**Our Ref: BR/41/13/
Your Ref:**

**Town & Country Planning Act 1990 (as amended)
Town and Country Planning (Development Management Procedure) (England) Order 2010 (as amended)
Application for Planning Permission**

Development	Demolition of existing buildings and redevelopment of the site with 6 no two bedroom dwellings
Location	Land to the rear of Holmlea Town Cross Avenue Bognor Regis

PROPOSED ELEVATIONS & FLOOR PLANS ~ PLOT 1

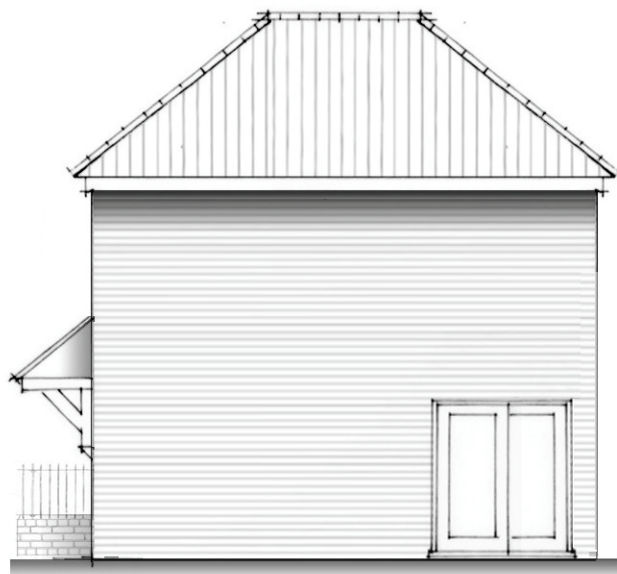
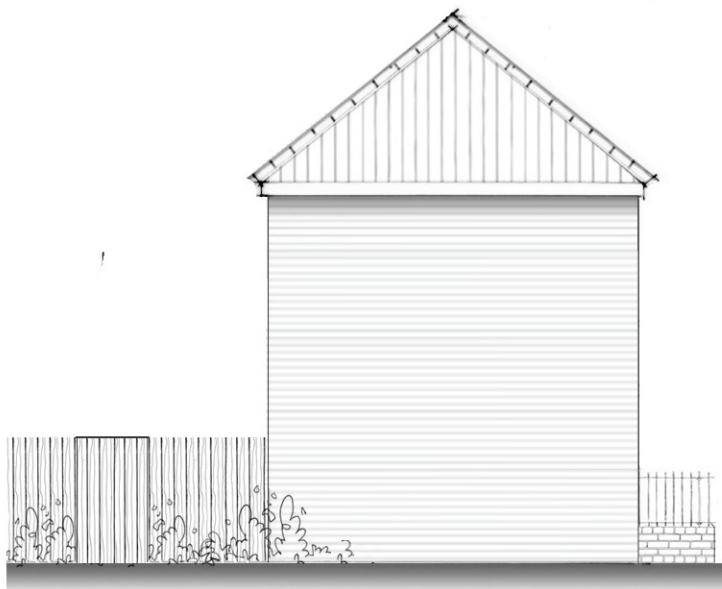
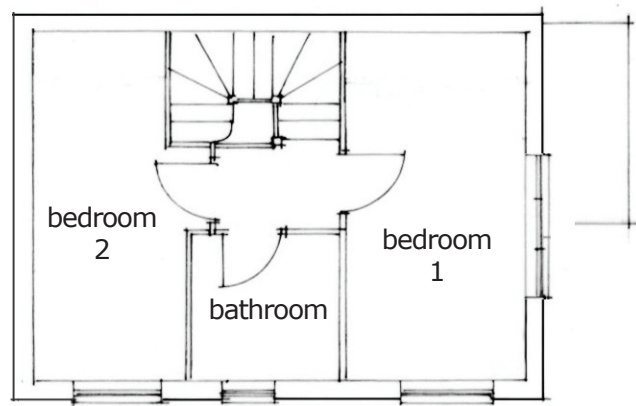
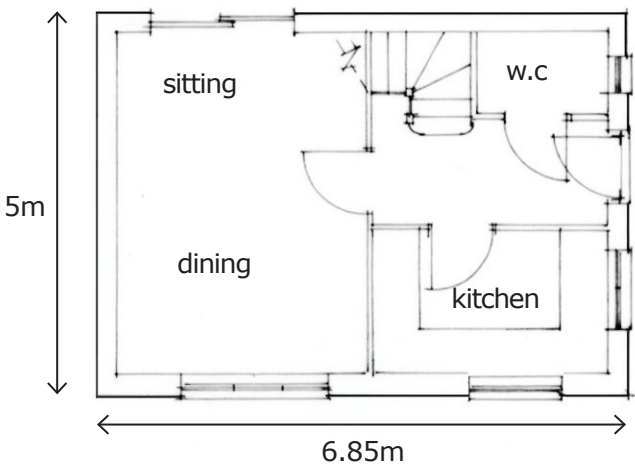
Plot 1 - floor & NW elevation do not accord. Please forward amended plans accordingly
